New South Wales EPA
**Berrima Cement Works
Alternative Fuels**
Submission Review

Issue 2 | 26 February 2016

Job number 245530-00

Figure 3 VOC off-white clinker emissions

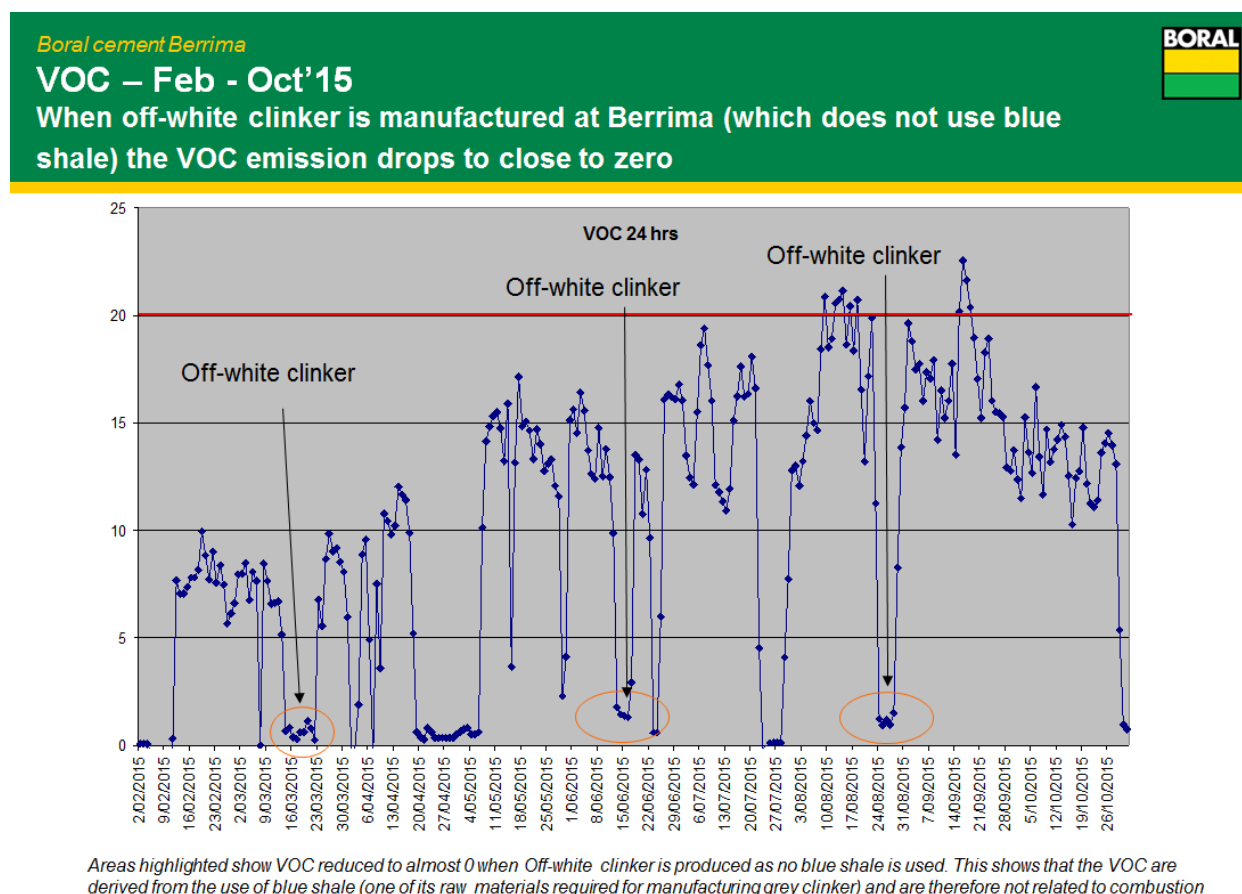
Based on the information provided by Boral we recommend that the 40ppm VOC limit is implemented at Boral.
